## MEMORANDUM

**TO:** Jean Fraser, Planner  
**FROM:** David Senus, P.E.  
**DATE:** January 16, 2013  
**RE:** 321 Commercial St. Mixed Use Development, Level III Final Site Plan/Subdivision Application

Woodard & Curran has reviewed the Response to Comments submitted on January 15, 2013 for the Level III Final Site Plan/Subdivision Application for the Mixed Use Development located at 321 Commercial Street in Portland, Maine.

STORMWATER PLANTER PLAN
SCALE: 1 INCH = 3 FEET

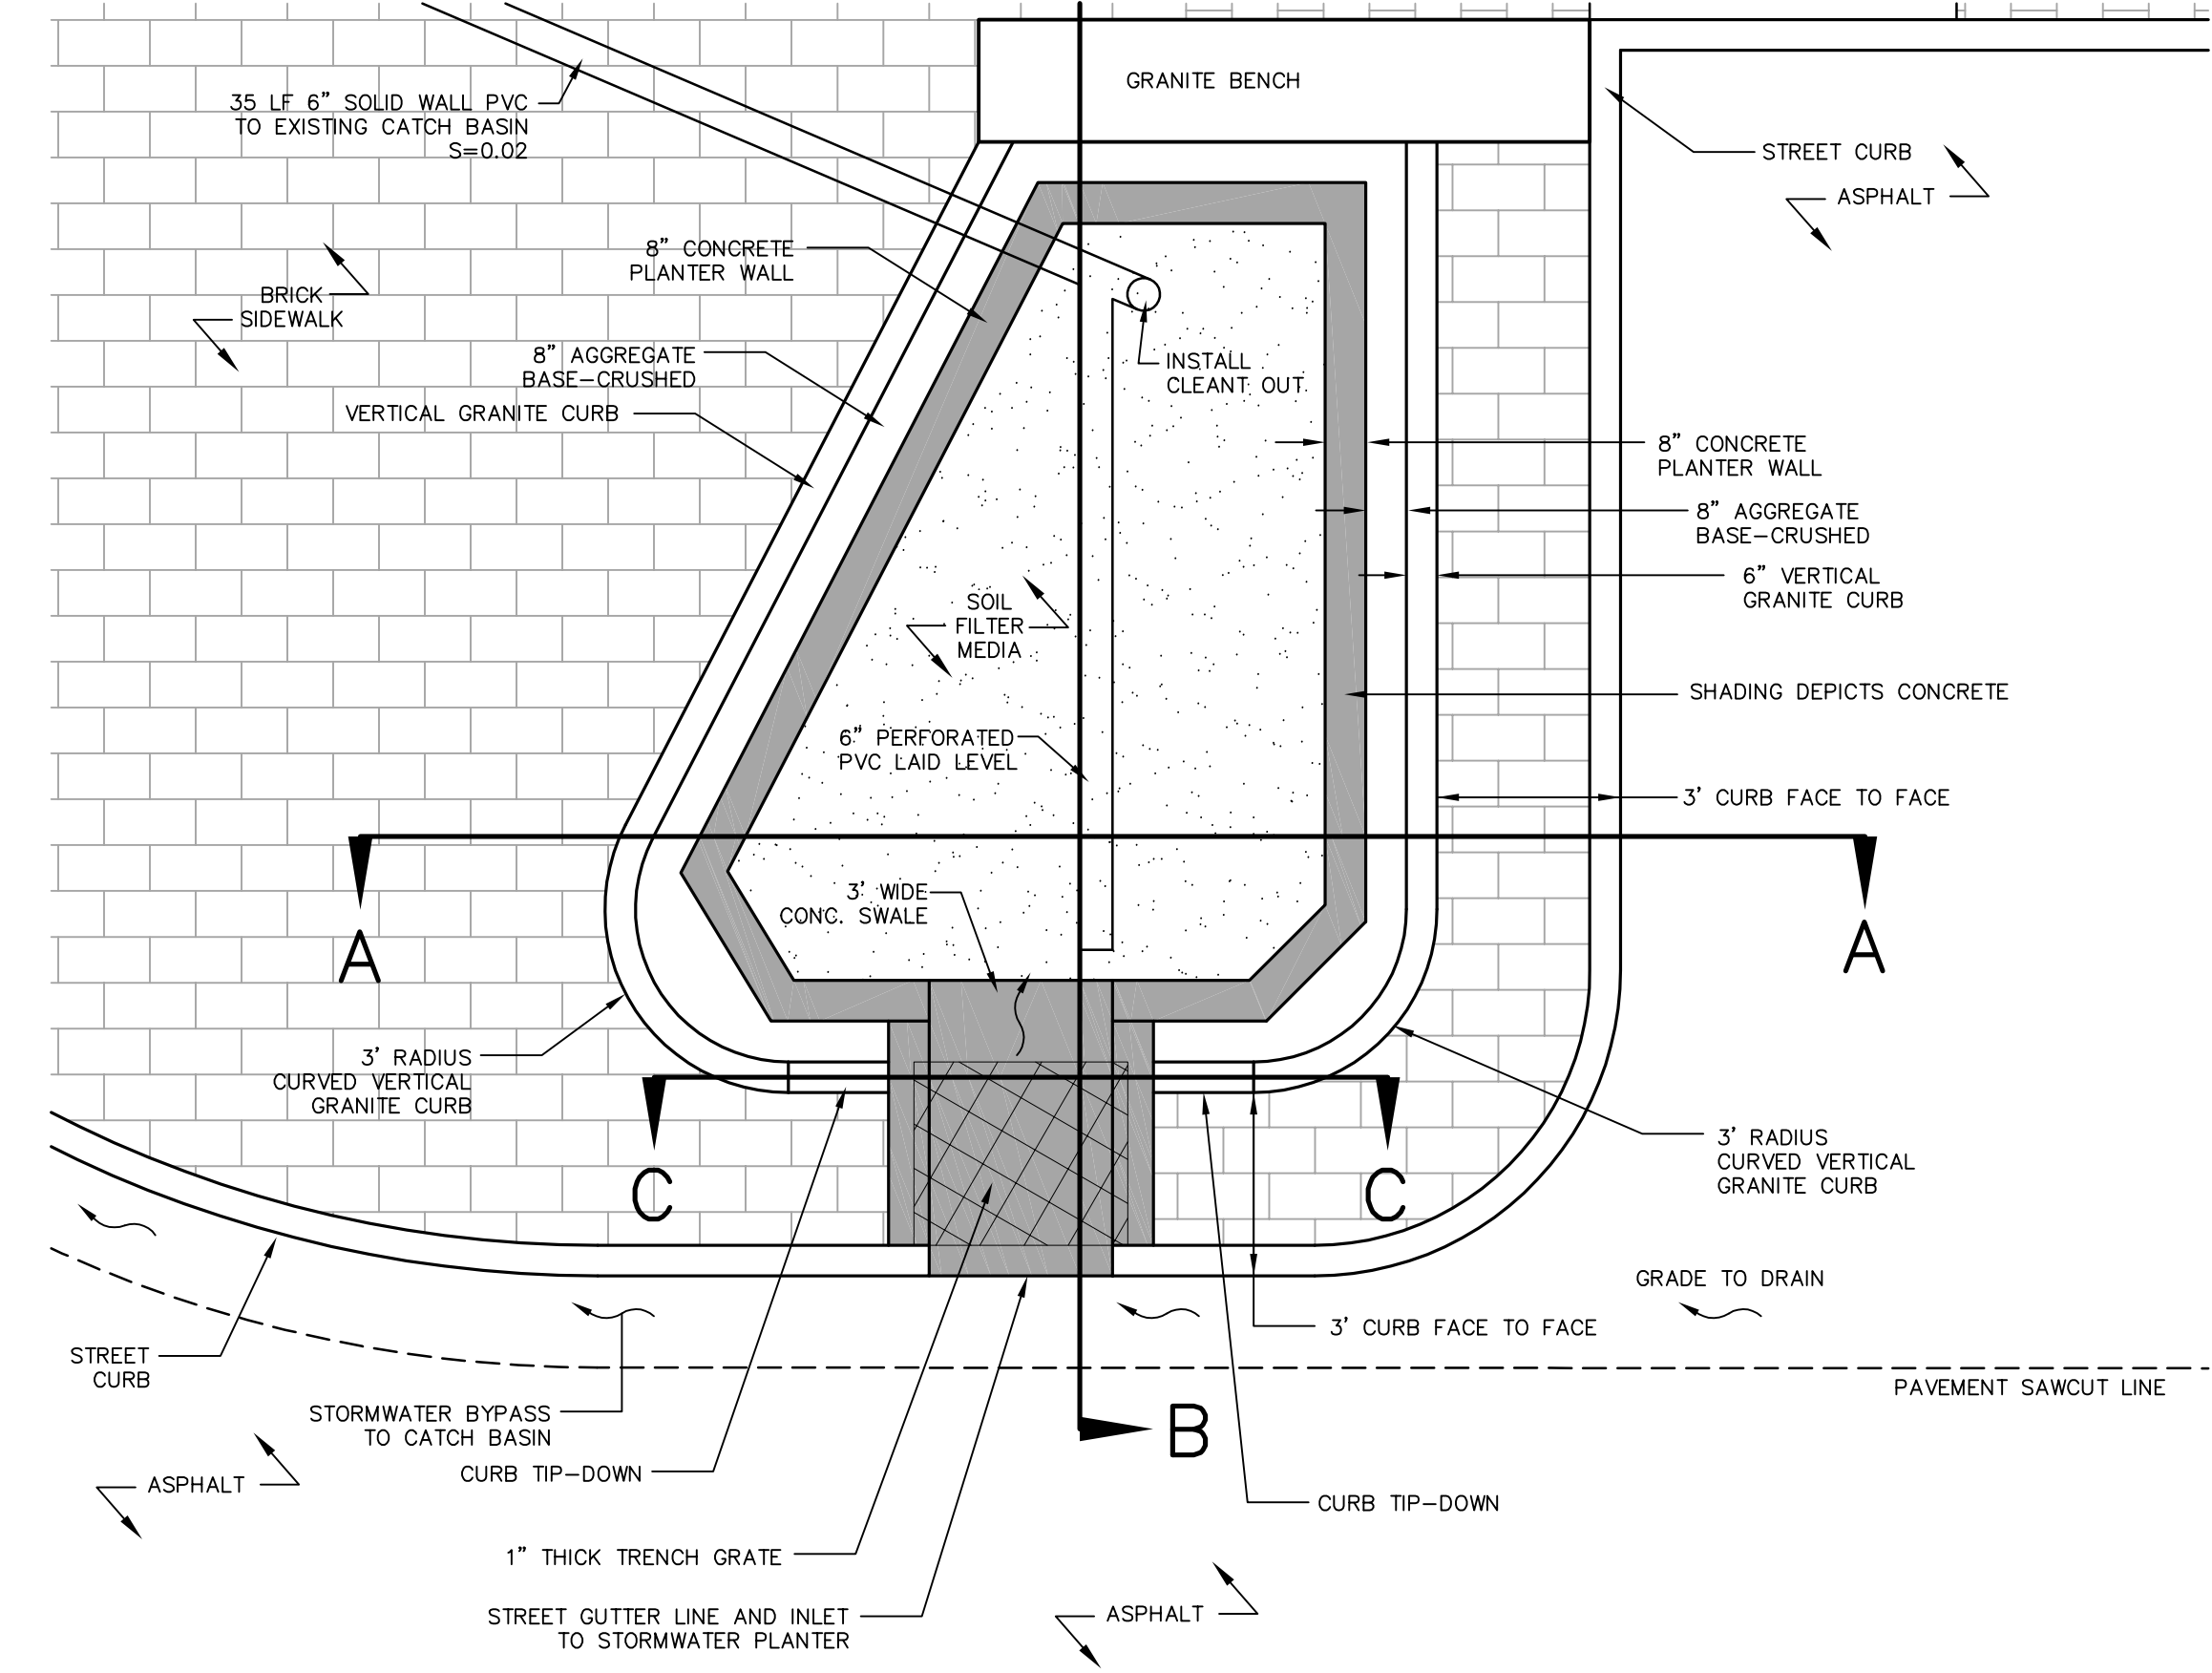
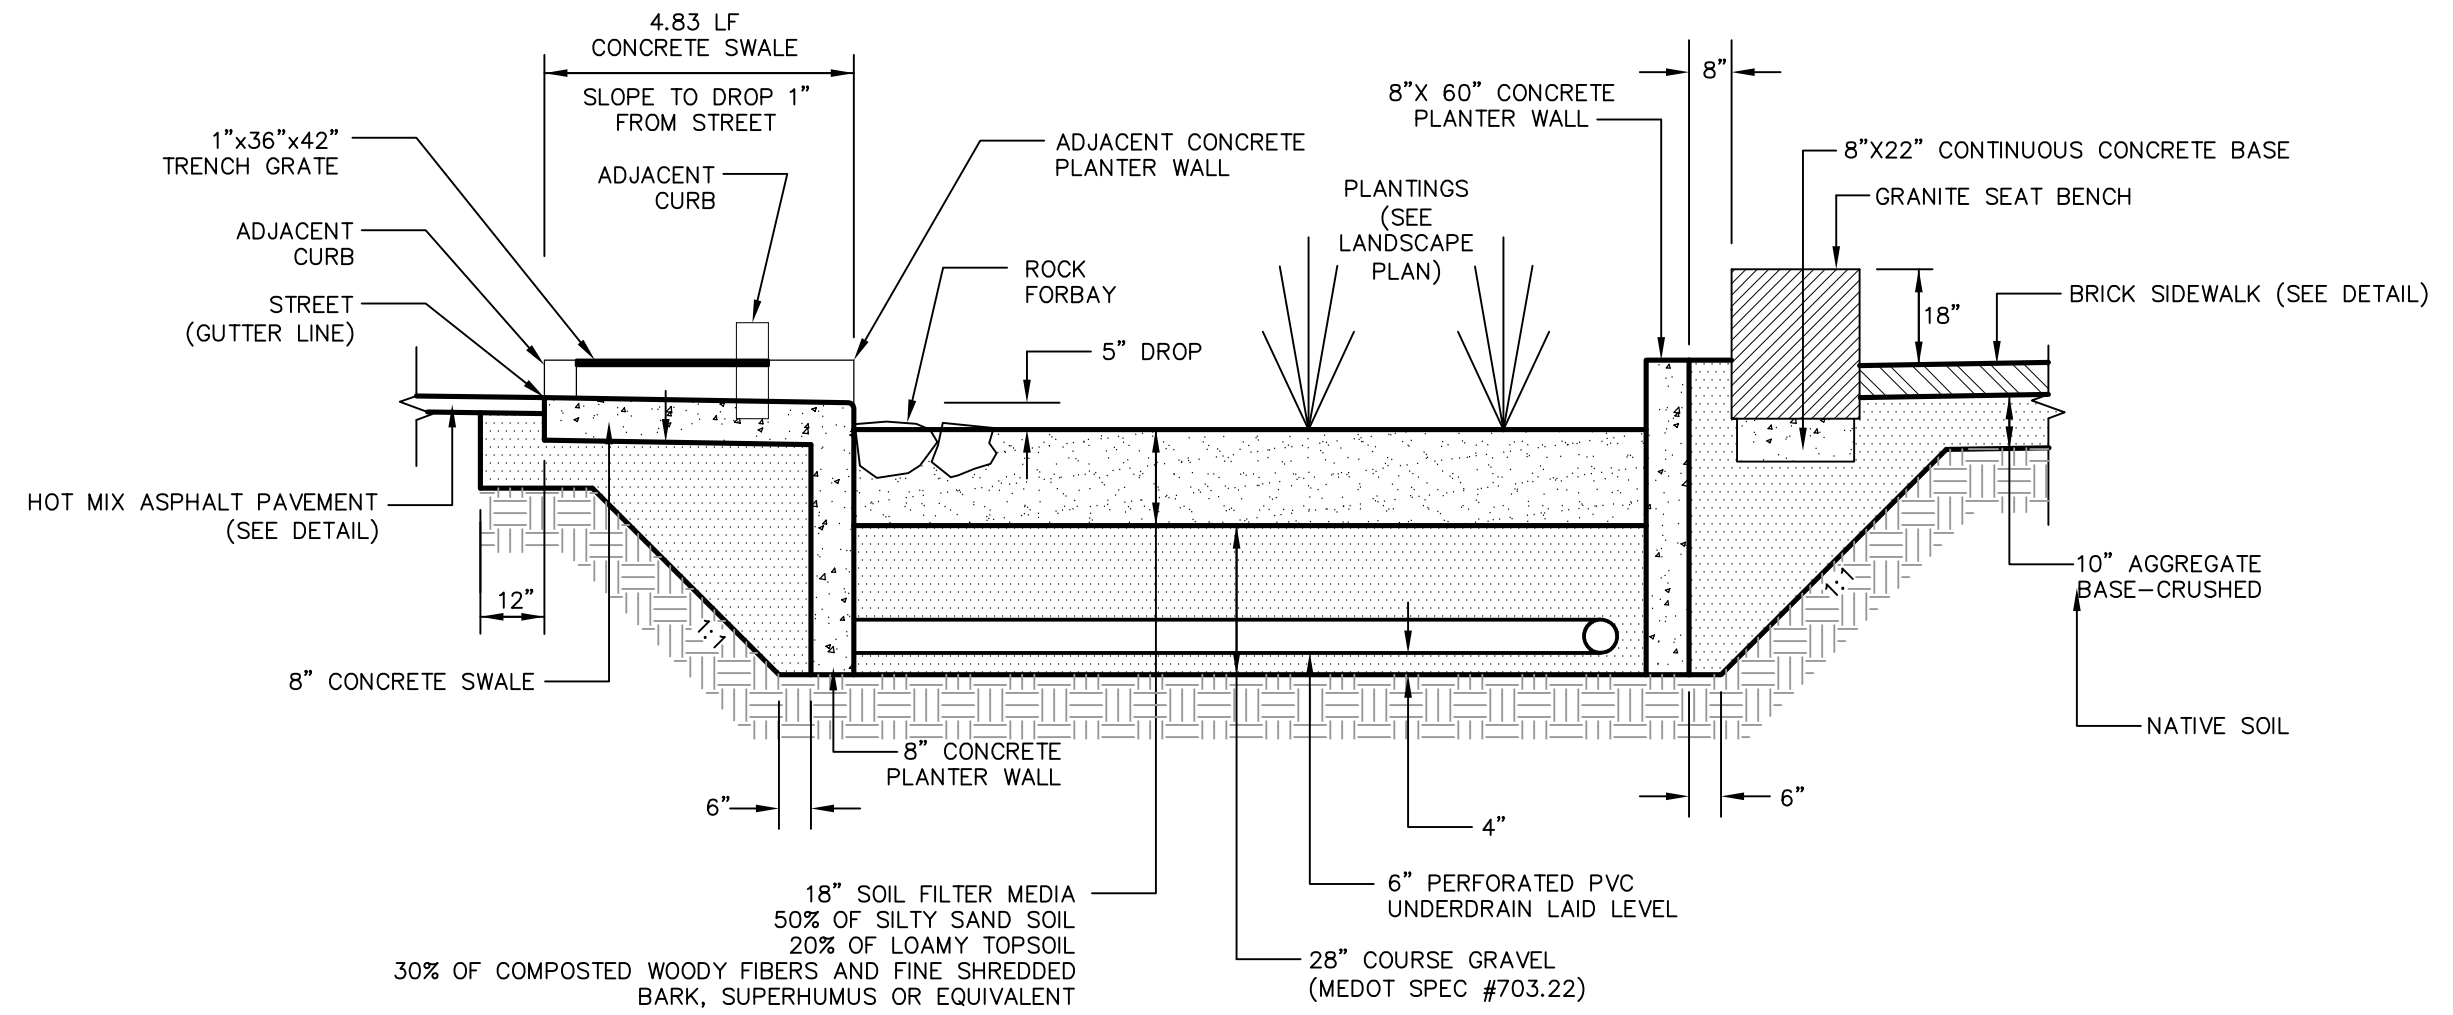
1. The Applicant has revised the project drawings to include a 6" underdrain below the Stormwater Planter with a proposed connection to an existing catch basin on Maple Street. The existing catch basin connects to the City's combined sewer system. We request that the Applicant revise the drawings to show the underdrain directly connected to the City's 18" RCP stormdrain in Commercial Street via an Inserta-tee connection.
